CITY OF ALBUQUERQUE

**Re: Rancho Candelaria
3615 Conrado NW
Request Permanent C.O. - Accepted
Engineer's Stamp dated: 8-5-14 (G13D023C)
Certification dated: 2-5-15**

**RE: Lot 8-P-1, Rancho de Candelaria
Grading and Drainage Plan
Engineer's Stamp Date (8-5-14)(File: G13D023C)**

ENGINEER'S SEAL	LOT 8-P-1 RANCHO DE CANDELARIA	DRAWN BY JDG
DAVID SOULE 14522 REGISTERED PROFESSIONAL ENGINEER	GRADING AND DRAINAGE PLAN	DATE 08-04-2014
8/5/14	Rio Grande Engineering 1606 CENTRAL AVENUE SE SUITE 201 ALBUQUERQUE, NM 87106 (505) 872-0898	SHEET # 1 OF 1
DAVID SOULE P.E. #14522		JOB #

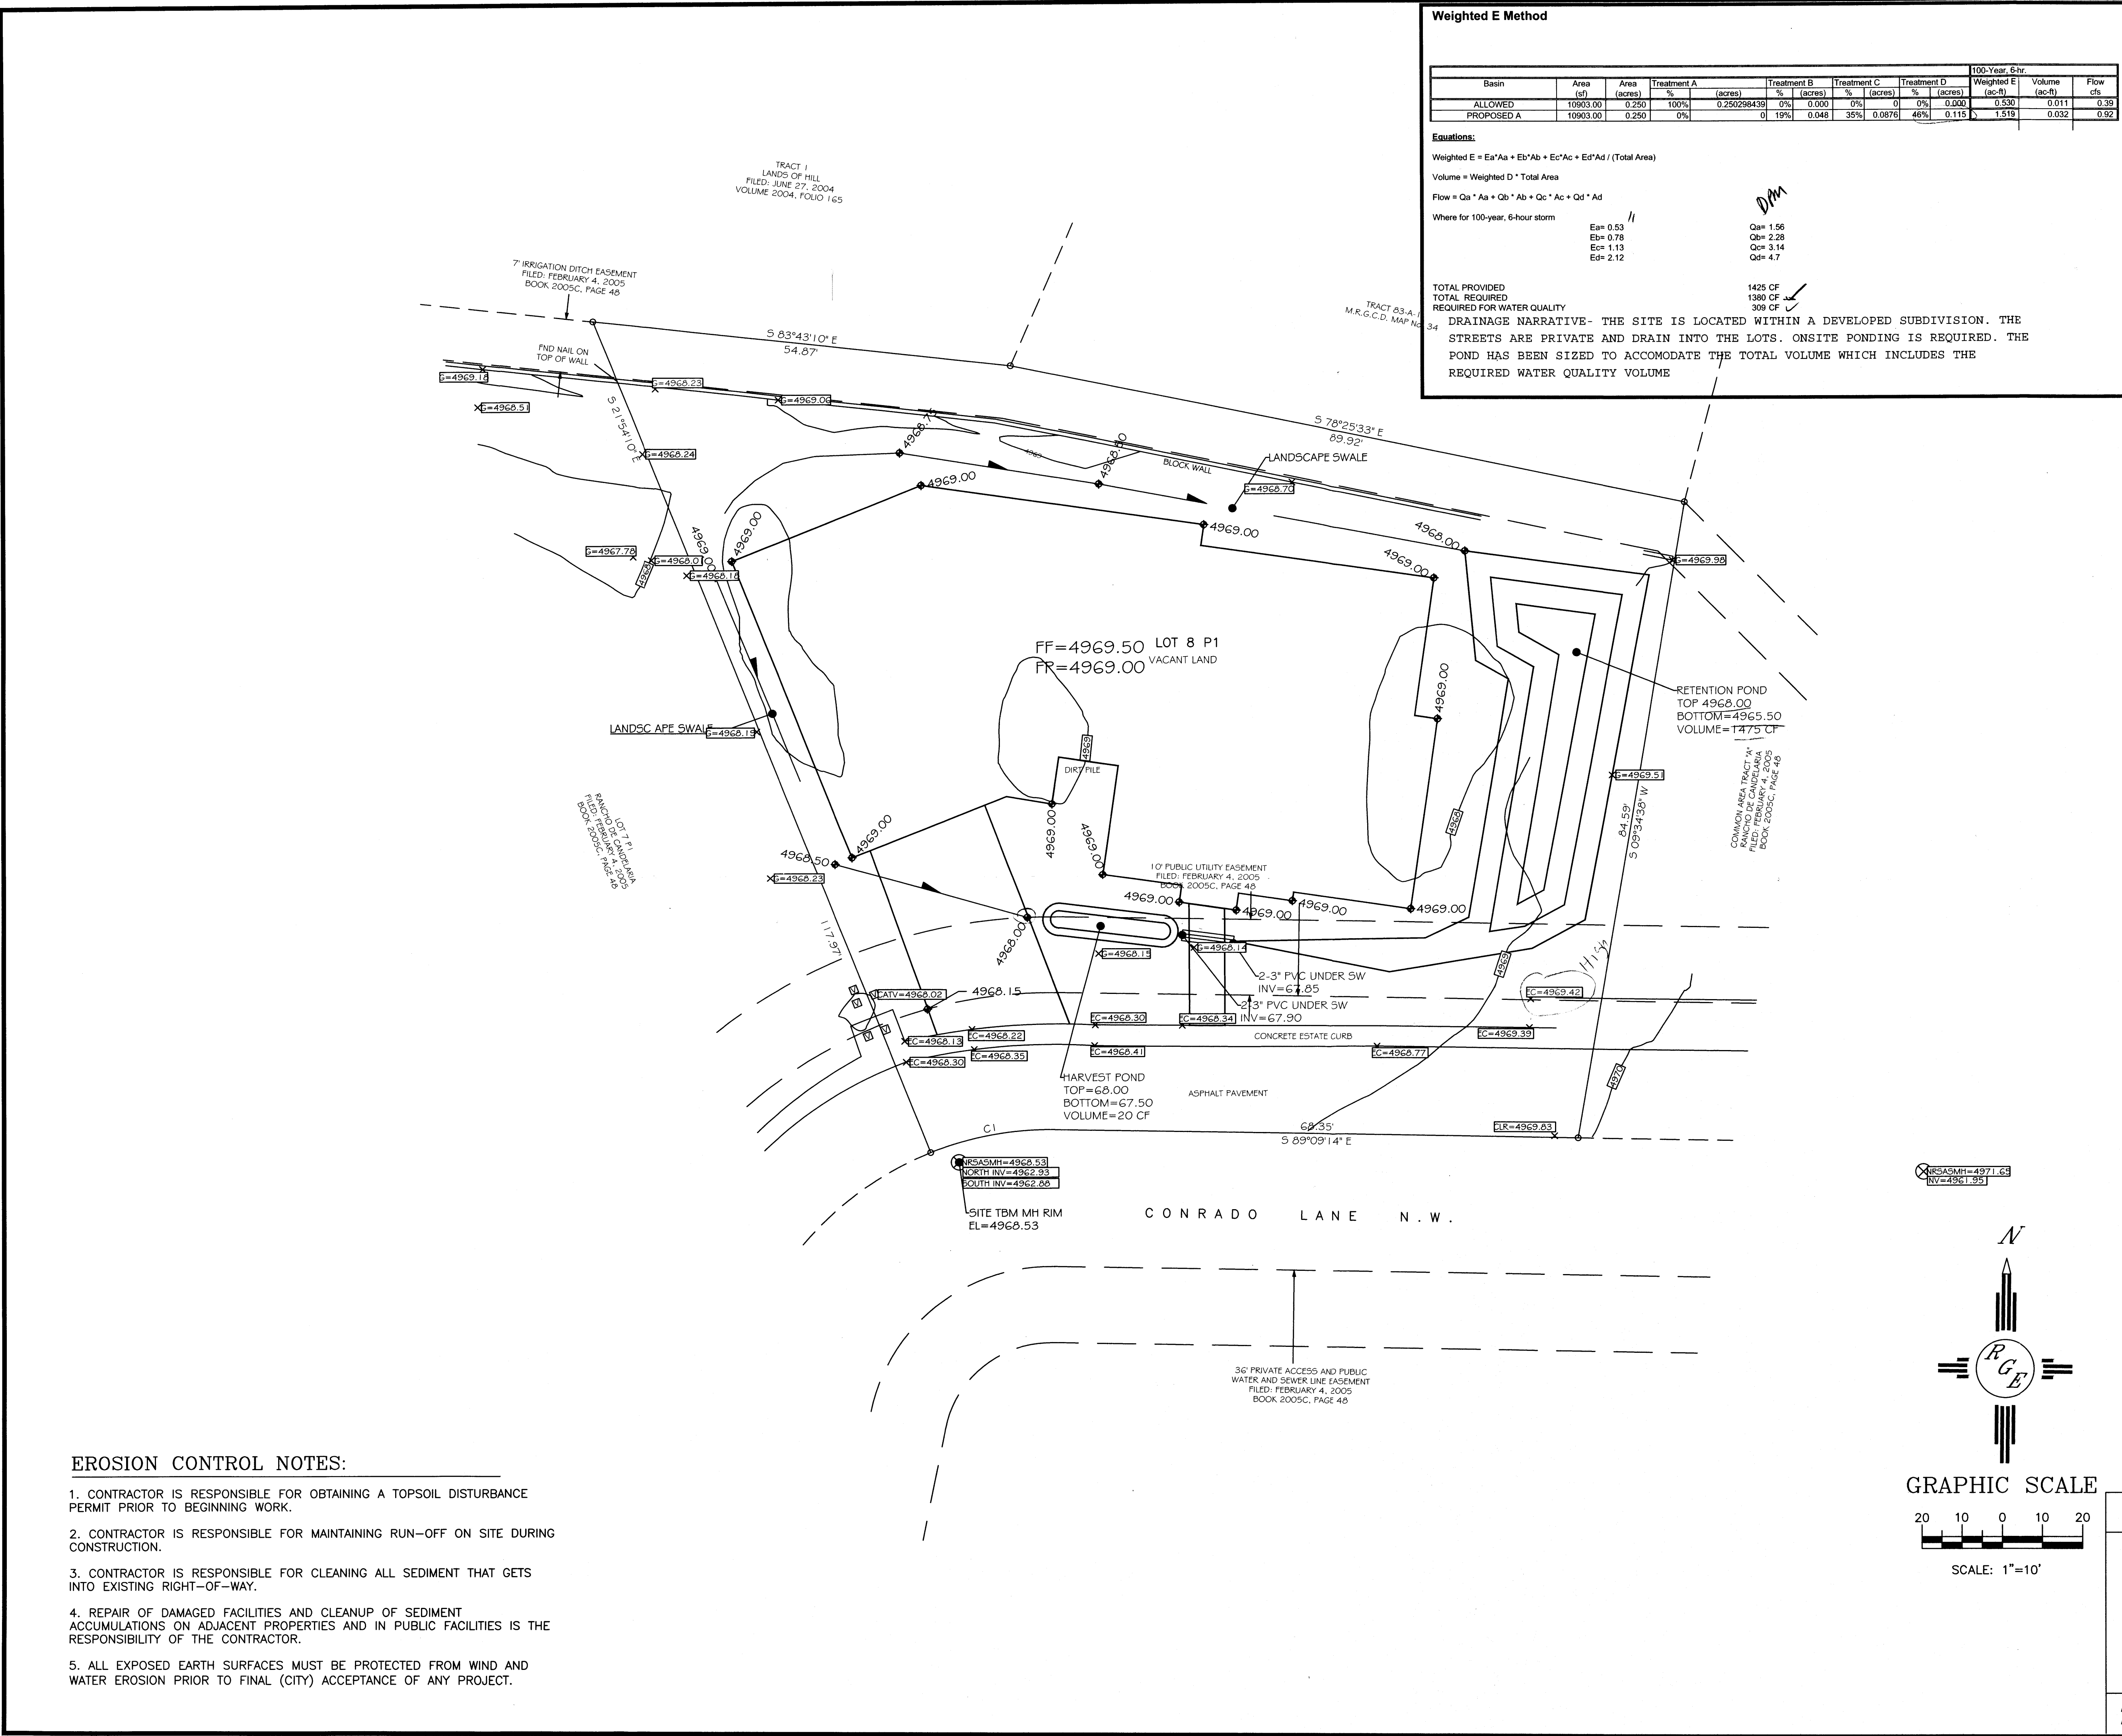
- Prior to Certificate of Occupancy, the As-built Grading and Drainage Plan must show roof, new paving, and roadway along frontage drain into ponds.
